DISTRICT COUNCIL
NORTH OXFORDSHIRE

Consultees for application 17/02131/F

District Planning Authority: Cherwell District Council	Case Officer: Matthew Coyne	Application No: 17/02131/F
Parish(es), Location and brief description: Adderbury St Georges Catholic Church Round Close Road Adderbury Demolition of existing chapel and erection of 1 dwelling		
Date referred to Area Liaison Officer:		14.11.17

Drawing Title
Proposed Layout

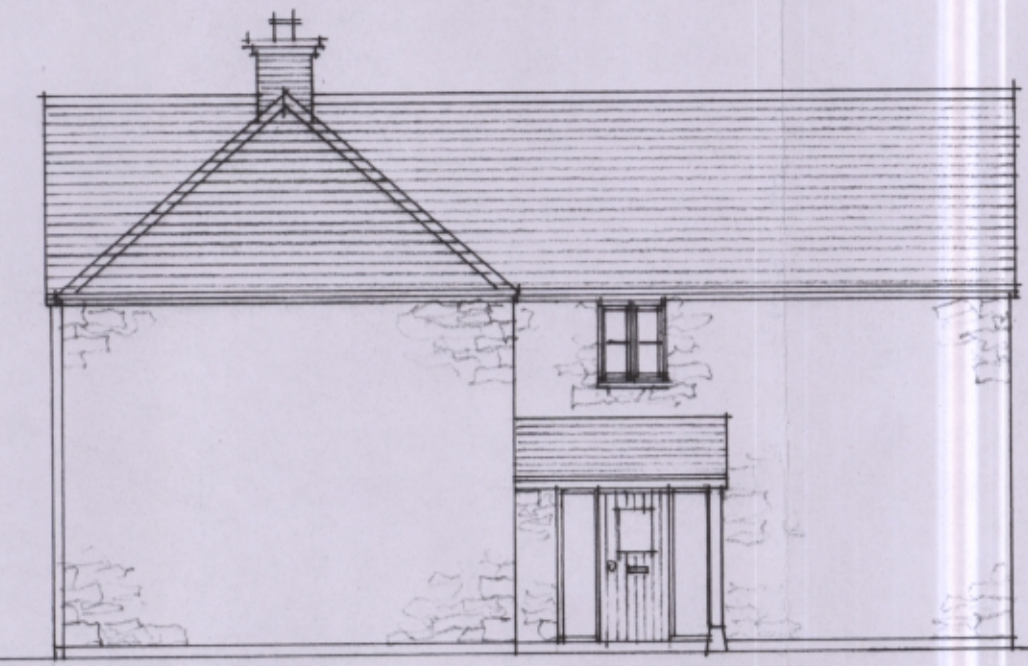
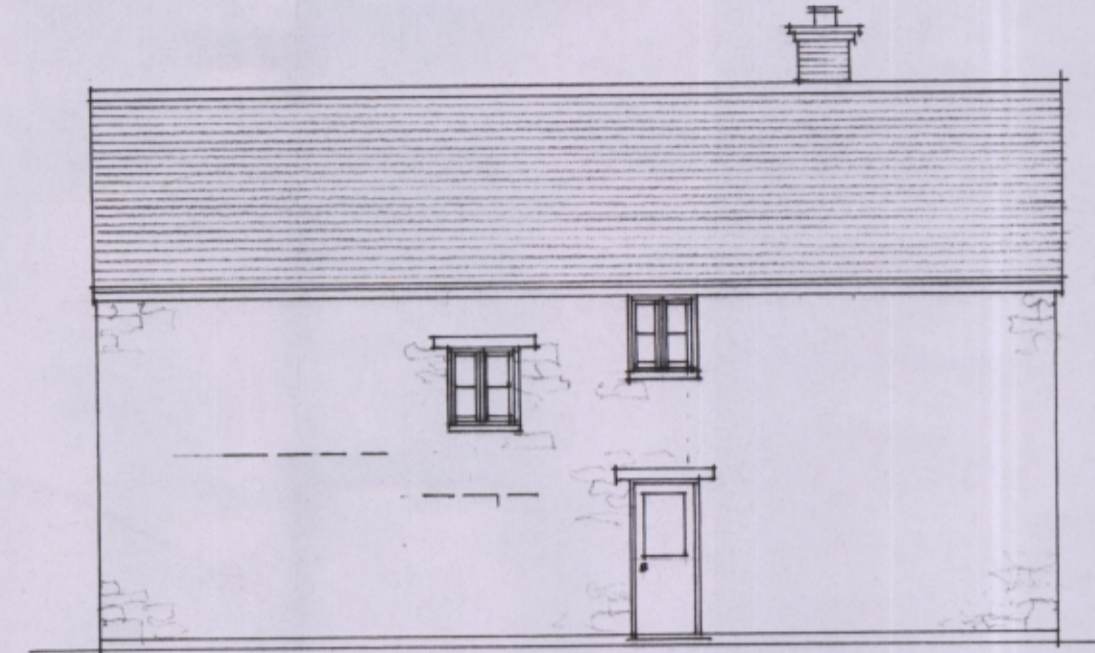
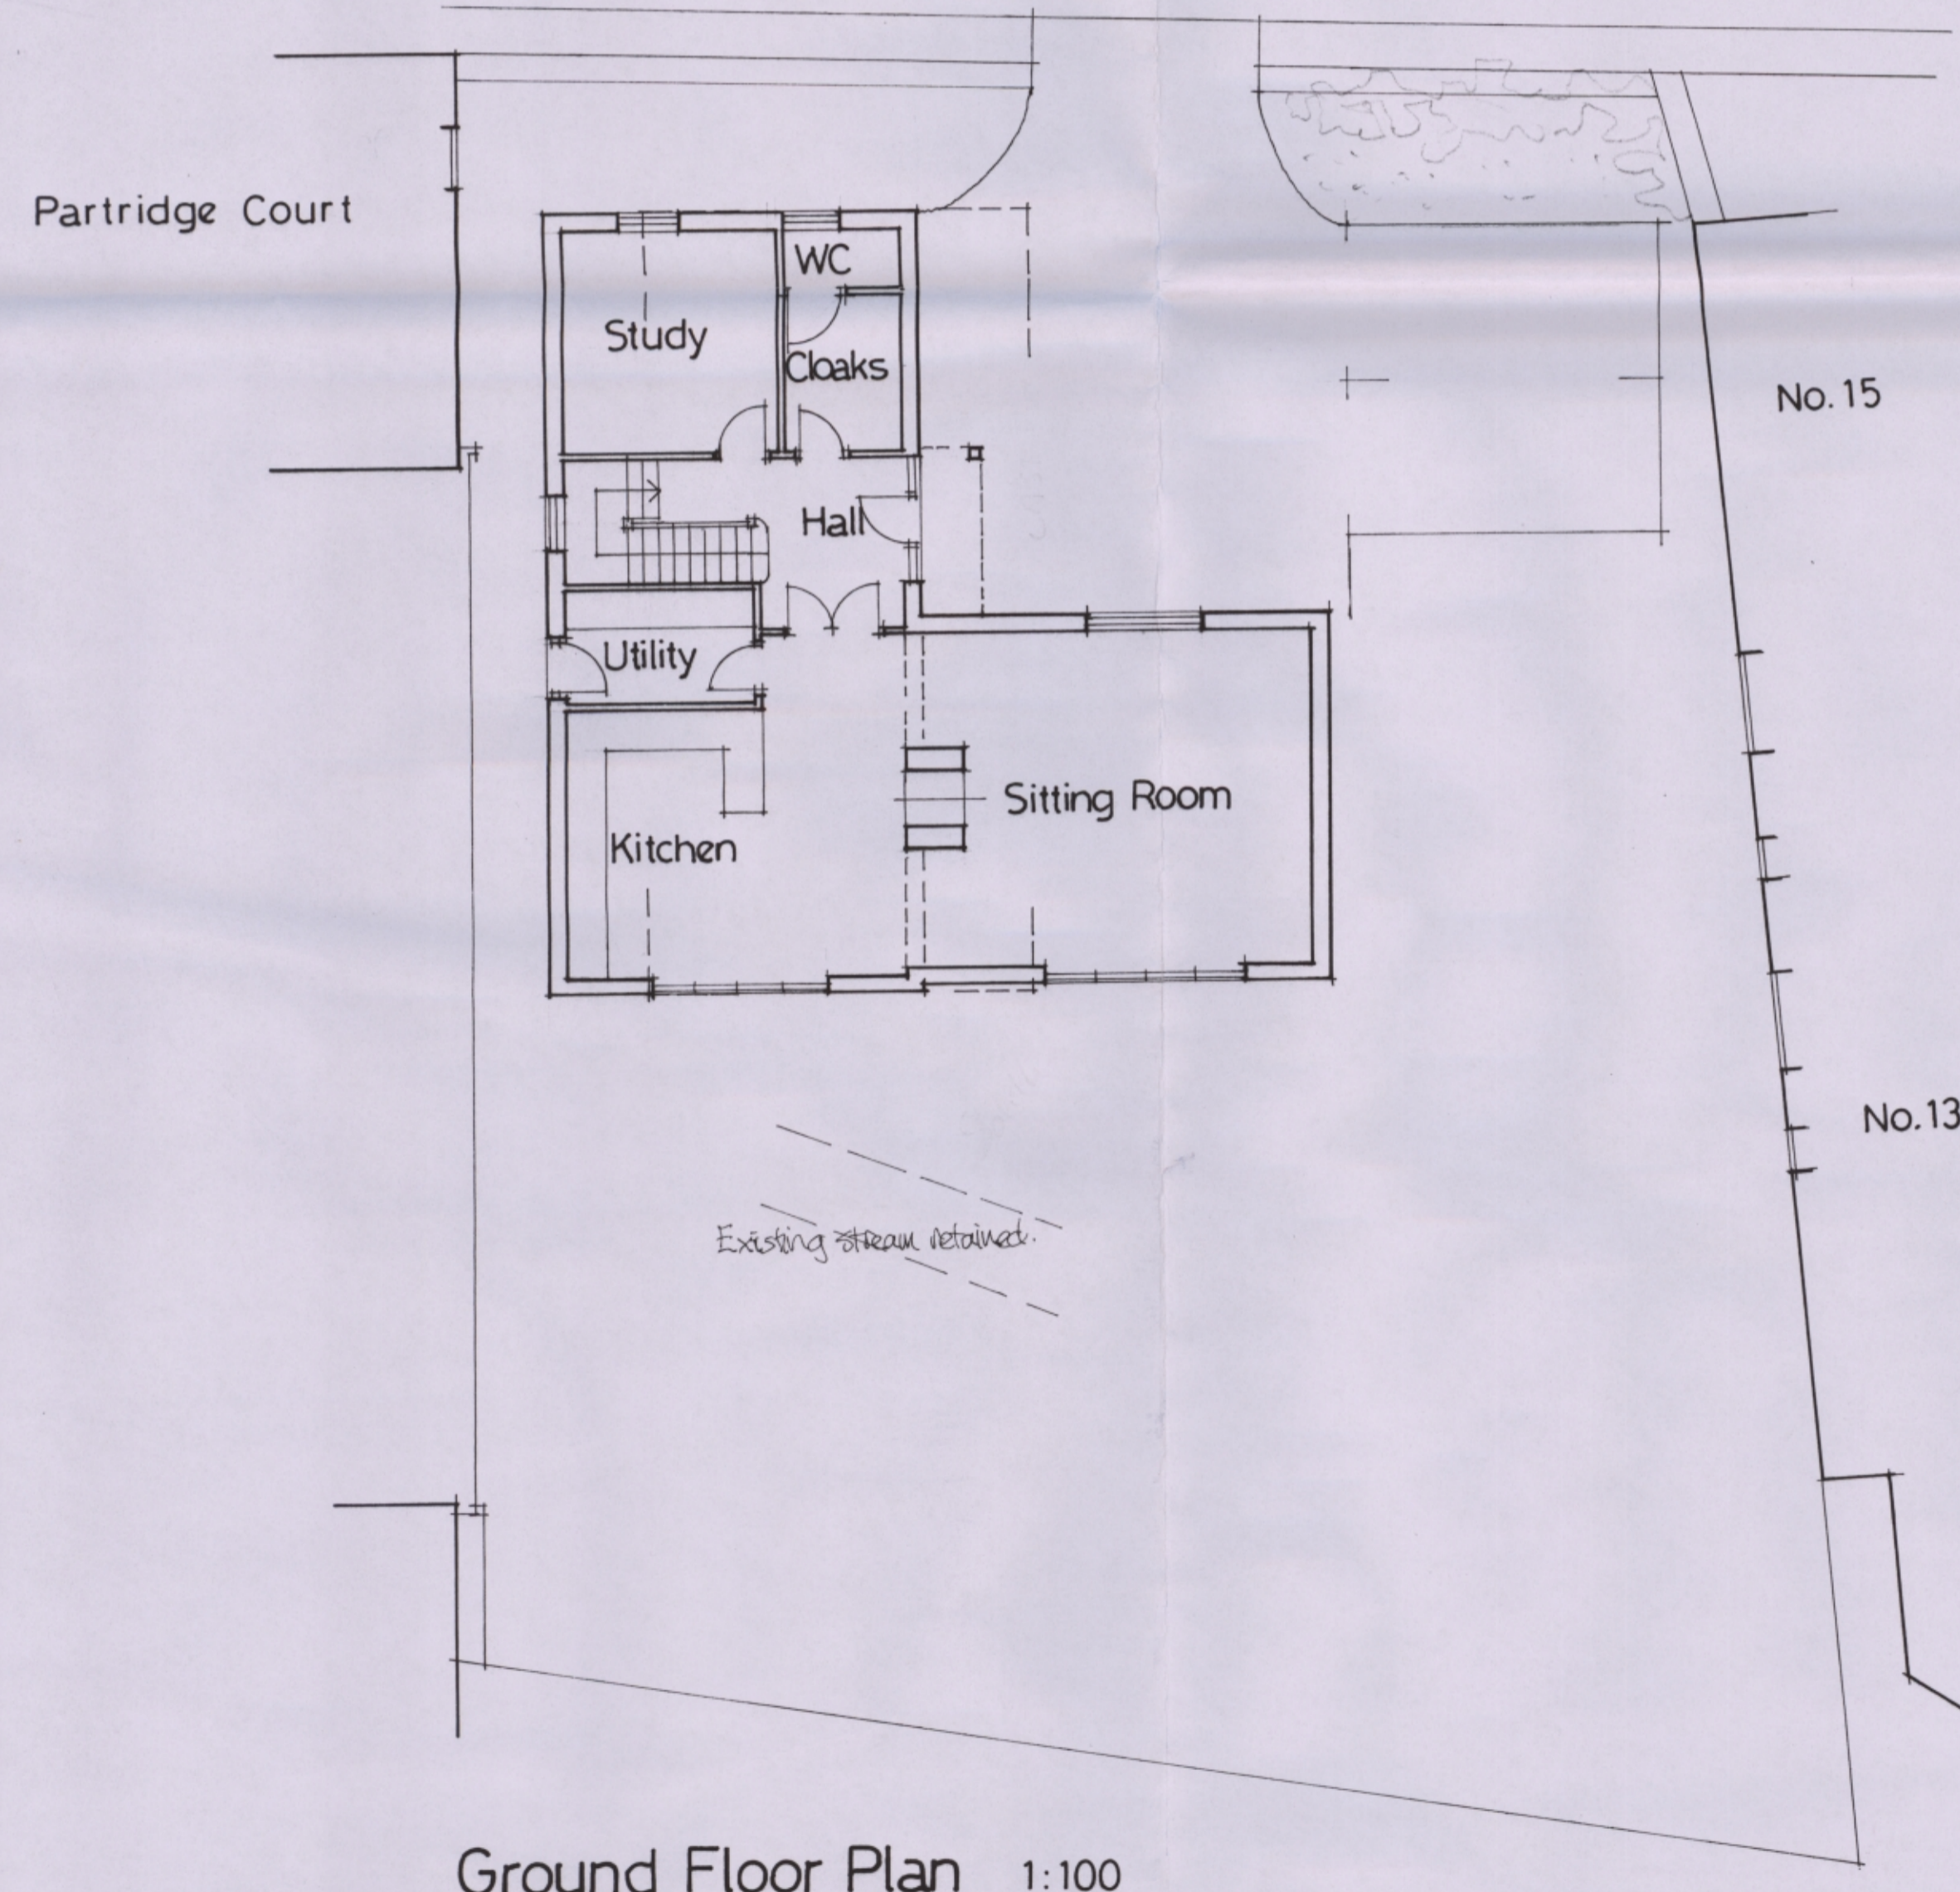
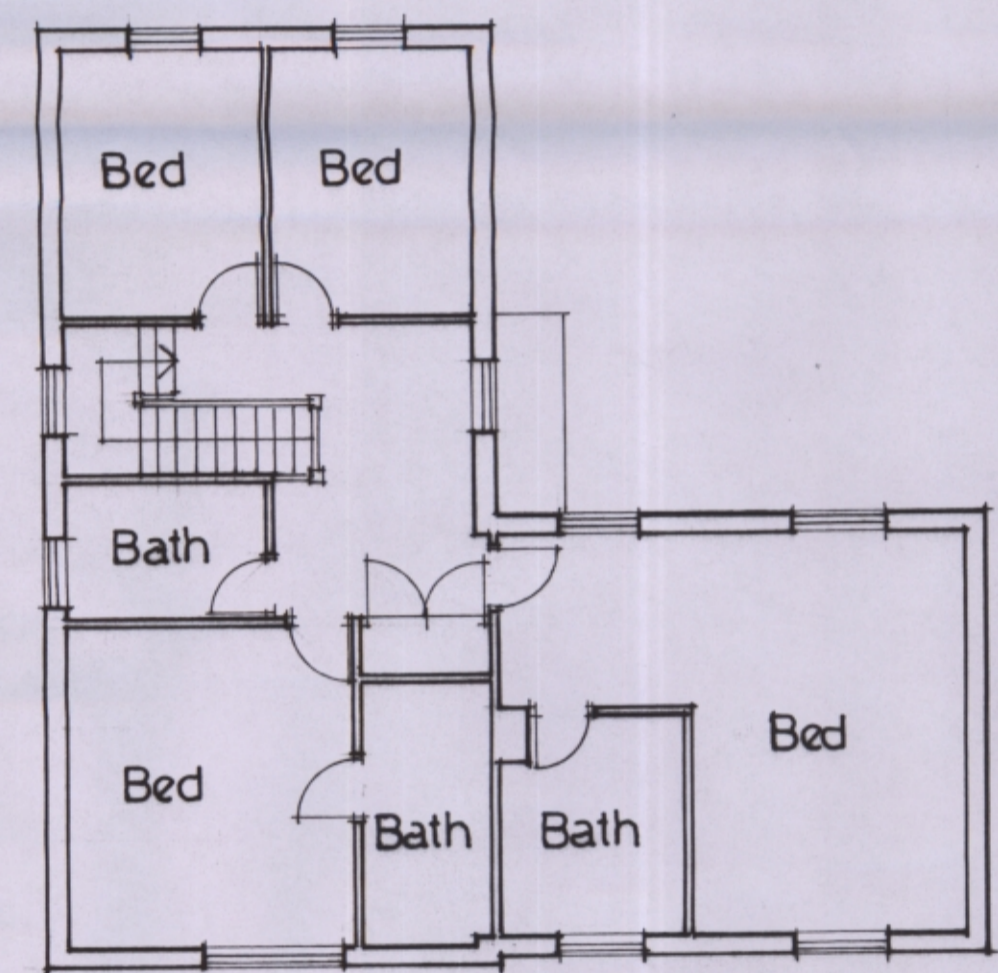
No objections to the development proposal, however the new building should be 'in-keeping' with the vernacular architecture of the area. The characterful existing stone wall on the frontage should be retained, driver's vis-splay permitting. The wall should be replicated on the other side of the drive.

Permeable paving to the drive will reduce runoff onto the street during a downpour.

For visual amenity two small ornamental trees are required in the rear garden. The character of the stonewalls to be enhanced by native honeysuckle. Hard and soft landscape proposals are required. Plant species, planting densities and supplied sizes are required. A commitment to landscape maintenance in respect if Royal Horticultural Society guidance would be appreciated.

In addition to the below, could the Parish Council please request that a couple of swift boxes are put on the new building, as there are swifts in the village and this could be a good site for them nesting
